STATE OF NORTH CAROLINA
DEPARTMENT OF TRANSPORTATION

Subject: **Additional Information in Response to the N.C. Division of Water Quality's and USACE's Email Questions** for the proposed new location facility from SR 2011 (Edgefield Road) to the Haw River at US 220 in Greensboro, Guilford County; Division 7; TIP No. R-2413 A & B; WBS Element No. 34429.1.1

Reference: 1) Application for Section 404 Individual Permit, Section 401 Individual Water Quality Certification, and Randleman Lake Buffer Authorization, May 14, 2013.
 2) NCDWQ/USACE Emails, dated June 4, 11, and 13, 2013.

SITE 23

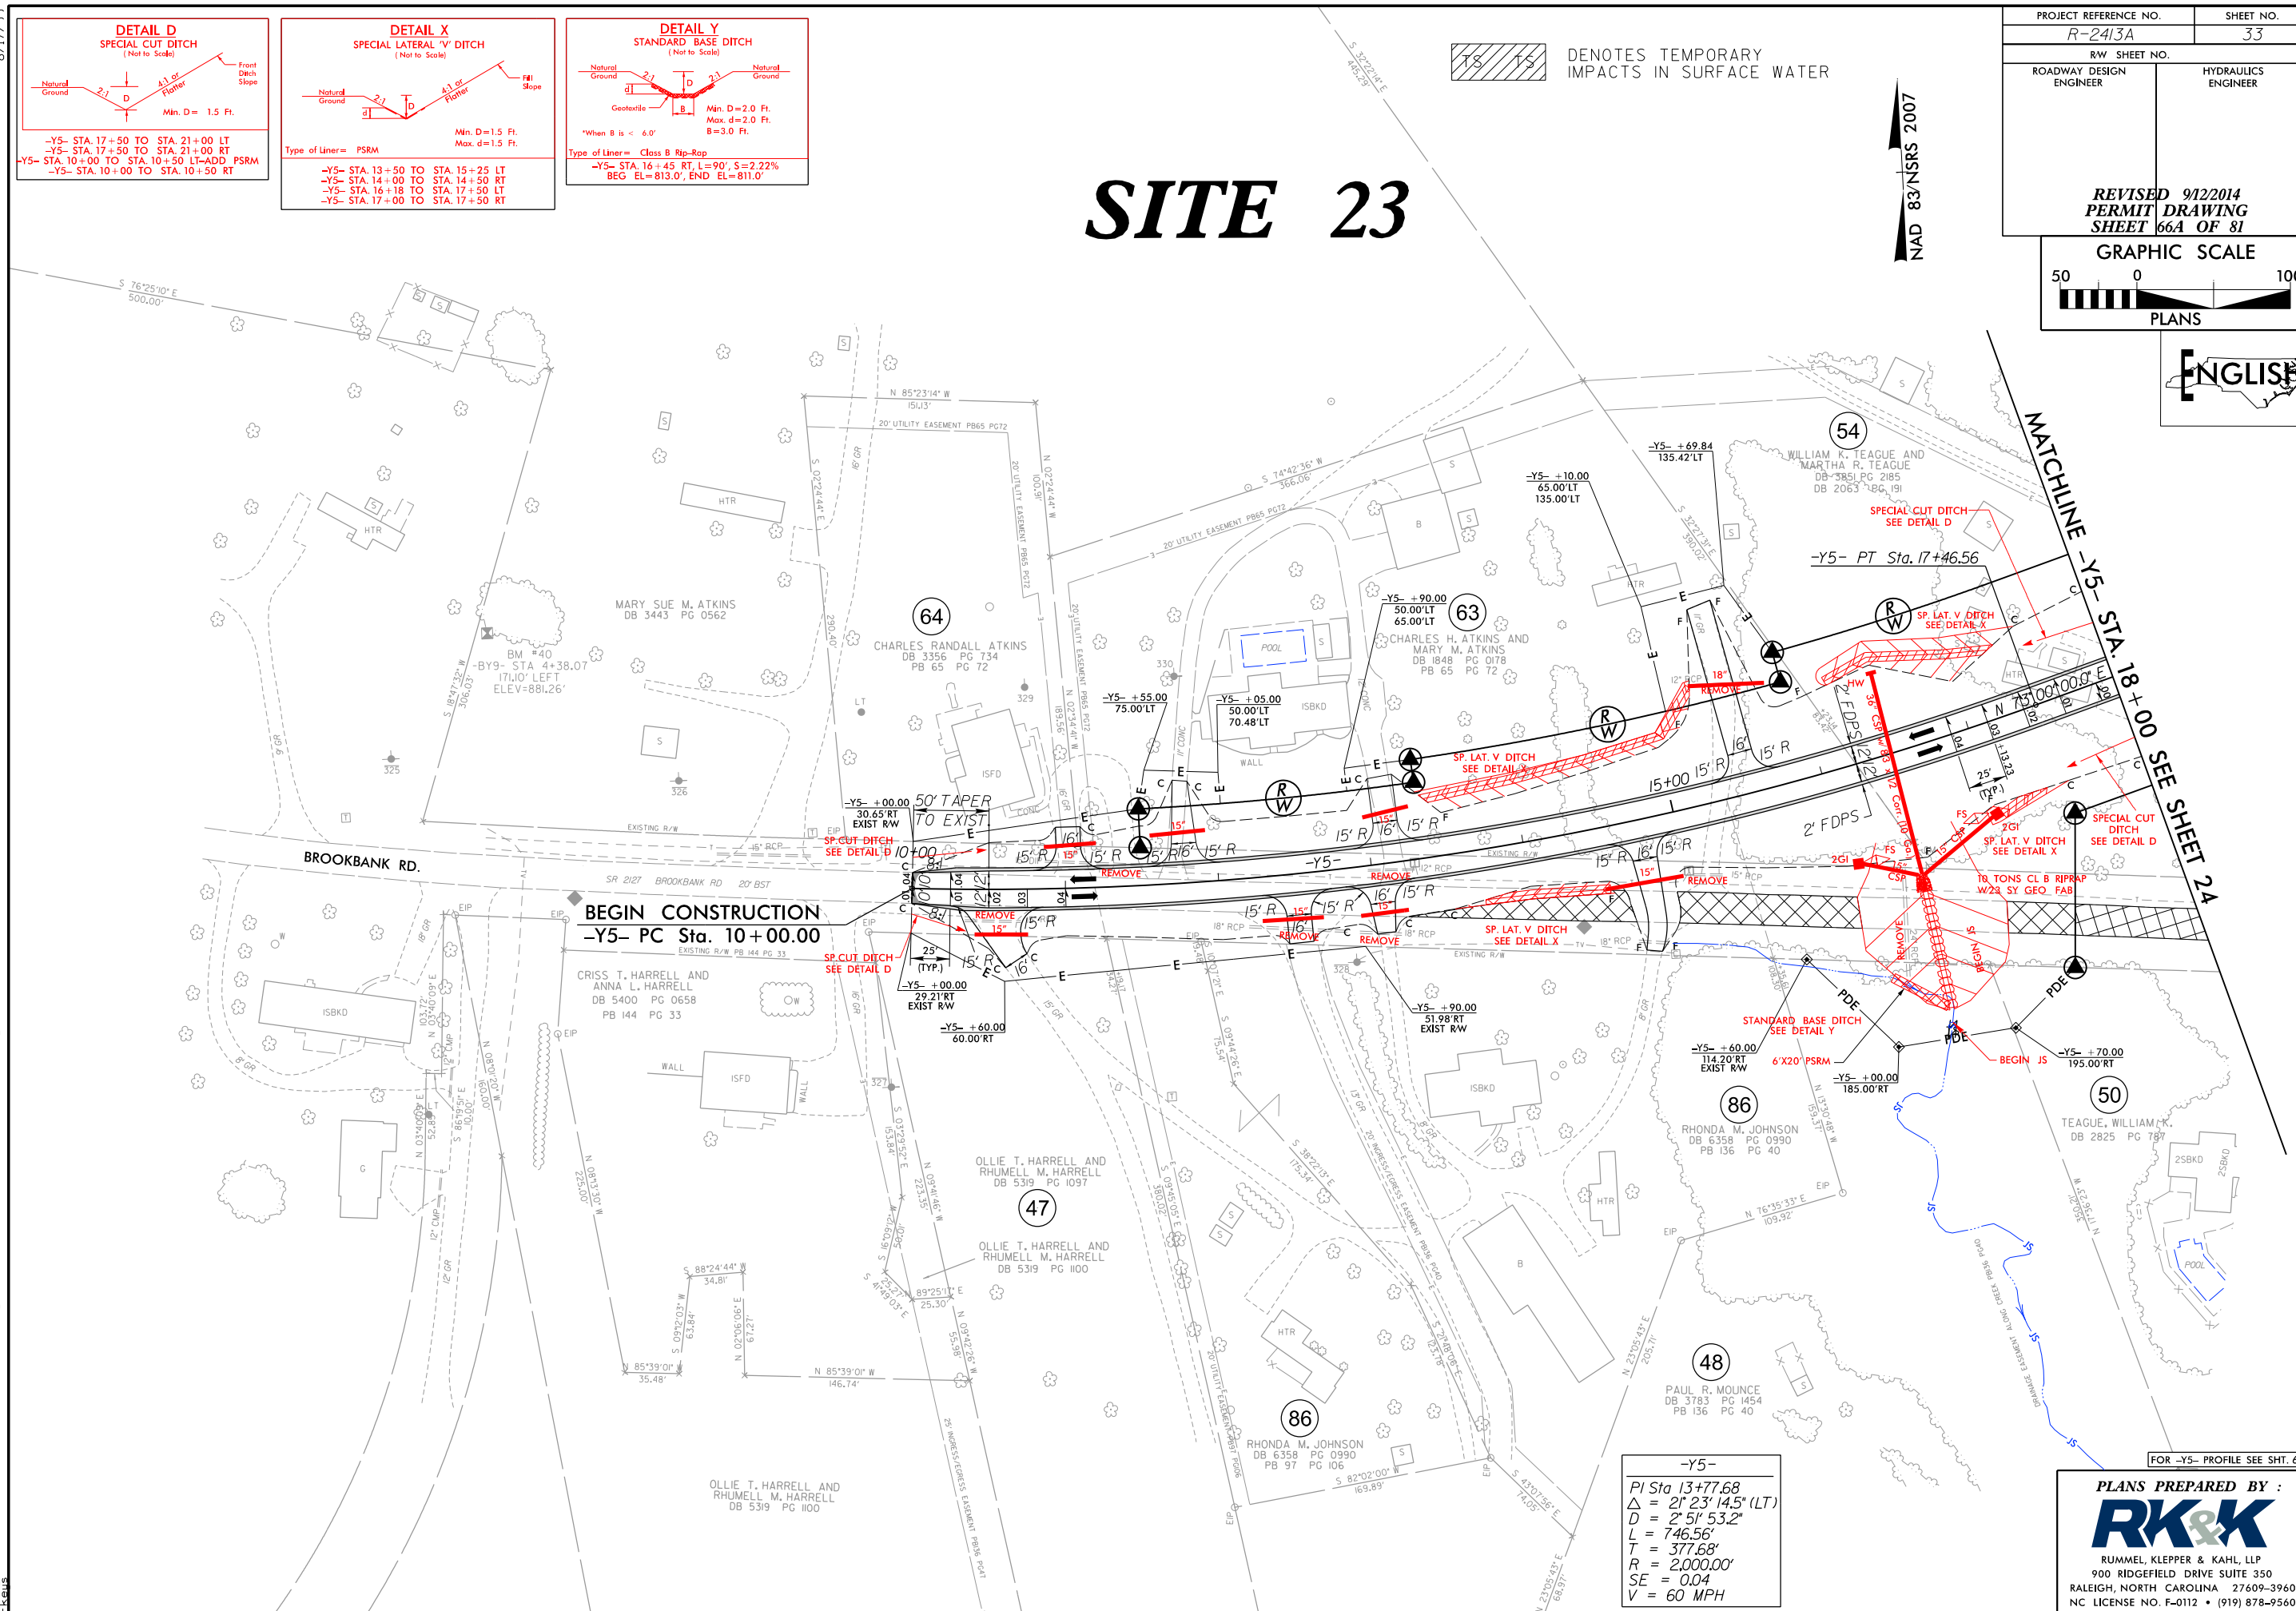
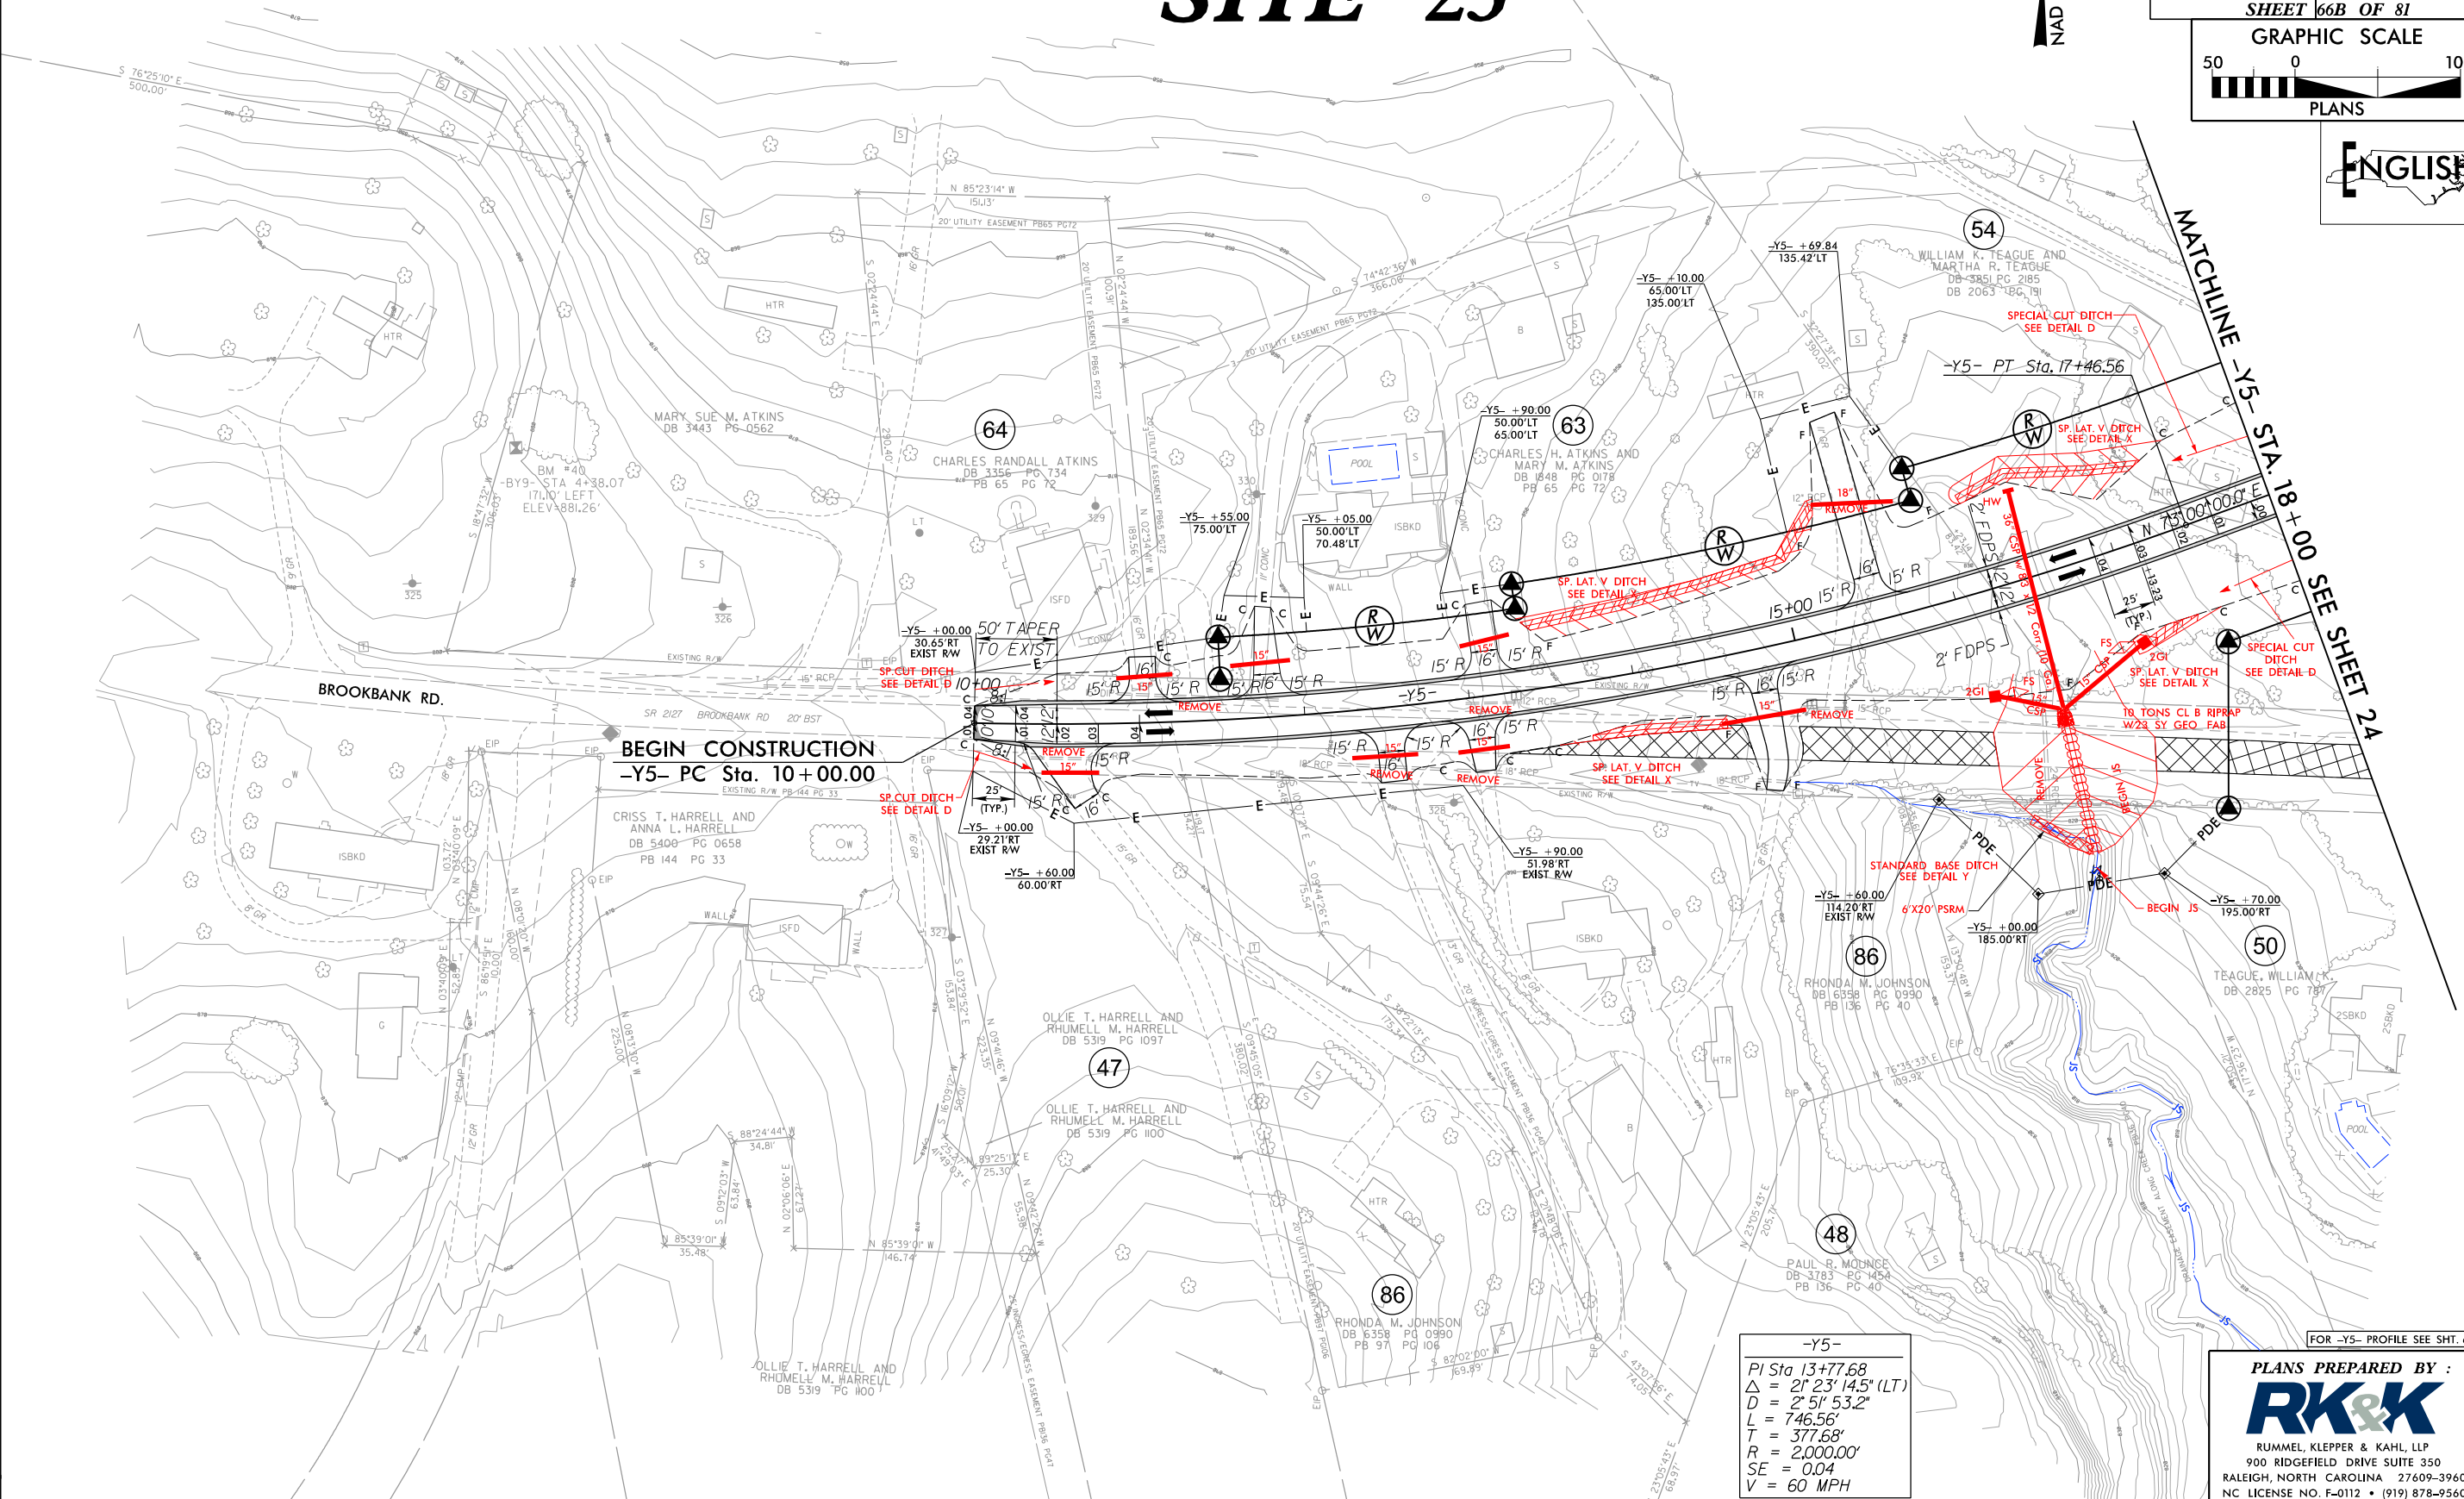
- 10) *Roadway plans sheet 33: At approximately sta no. 17+ 46, there is a PDE that's tied to a jurisdictional stream. Are there stream impacts associated with the PDE? If so, this should be a permit site.*

There are no direct impacts to the stream since the stream starts below the end of ditch and just above PDE line. There maybe temporary impacts with the construction in this area. A new site, Site 23, has been added to reflect these temporary impacts.

PROJECT REFERENCE NO. R-2413A	SHEET NO. 37B
R/W SHEET NO. ROADWAY DESIGN ENGINEER	HYDRAULICS ENGINEER
INCOMPLETE PLANS DO NOT USE FOR R/W ACQUISITION	
PRELIMINARY PLANS DO NOT USE FOR CONSTRUCTION	
REVISED 09/03/2014 PERMIT DRAWING SHEET 74 OF 81

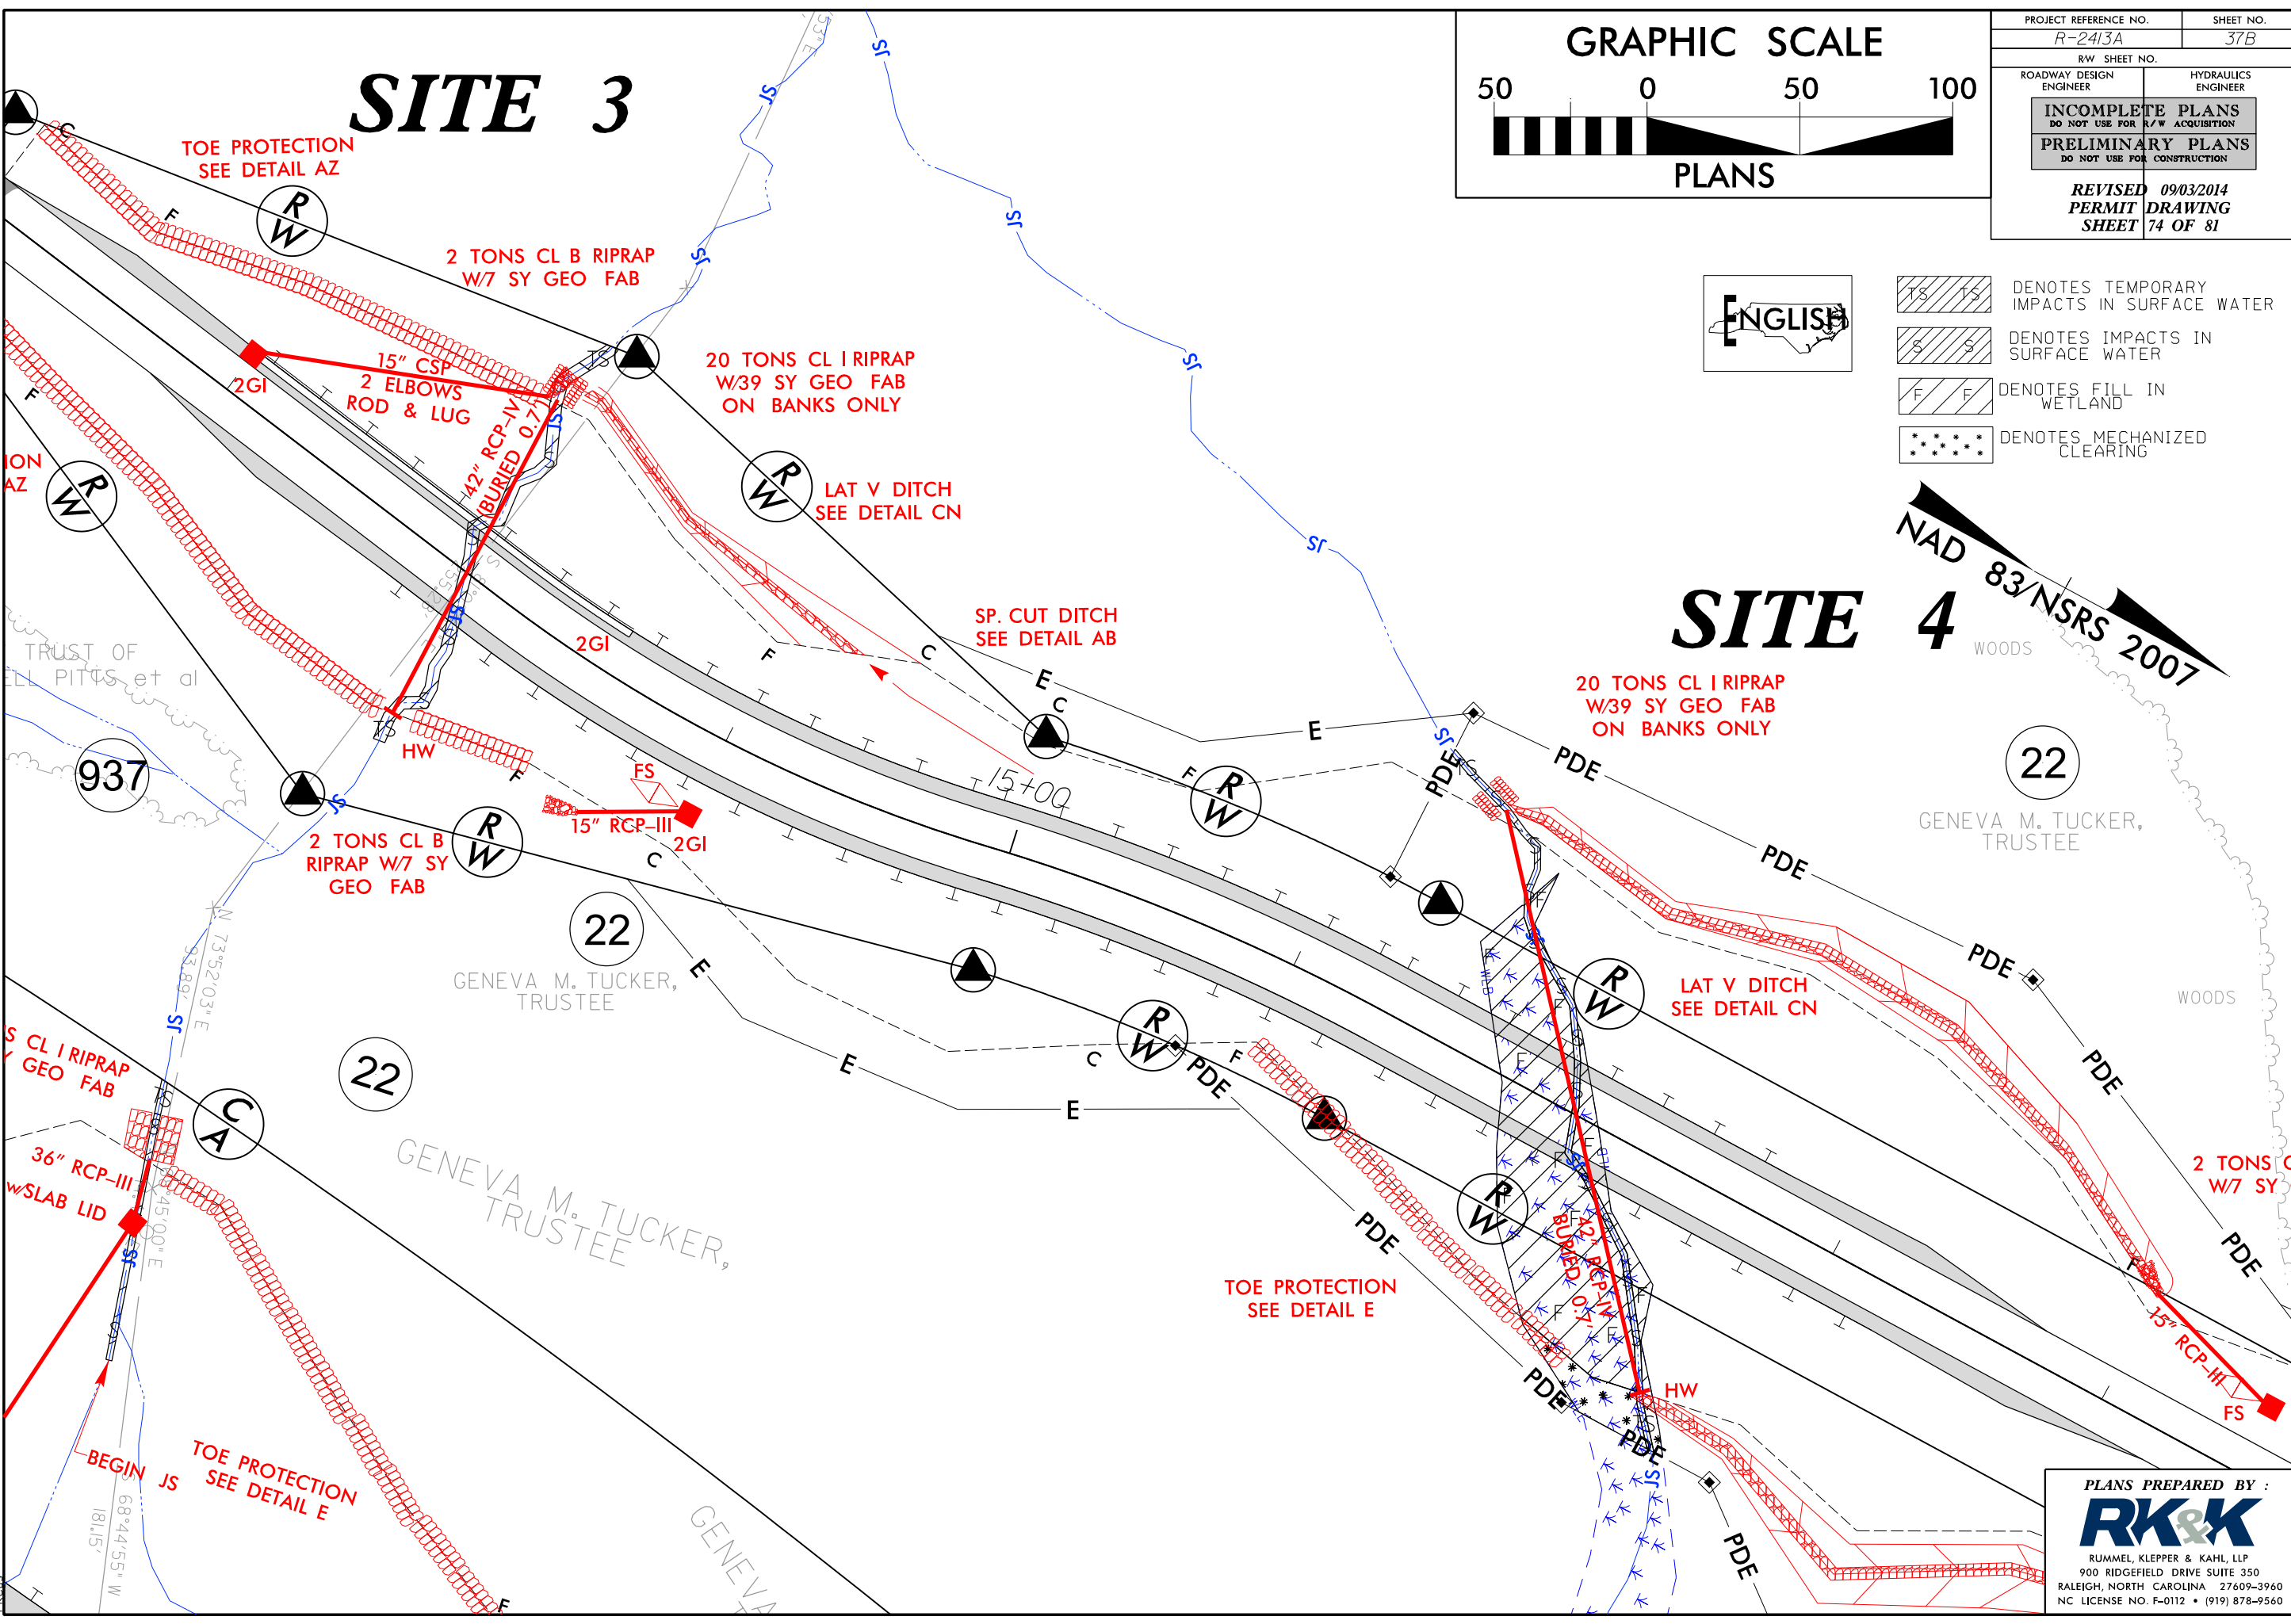
- 4) *Permit site 4: There are mechanized clearing impacts listed at site 4. There are no mechanized clearing impacts shown on the plans. Also the 4C meeting minutes state that there are no mechanized clearing impacts at site 4. Please update.*

There is mechanized clearing at Site 4 (Permit Sheet 74). The comment made during the 4C meeting must have been made while looking at the Site 4 impacts on Permit Sheet 13. Site 4 is depicted on two permit sheets.
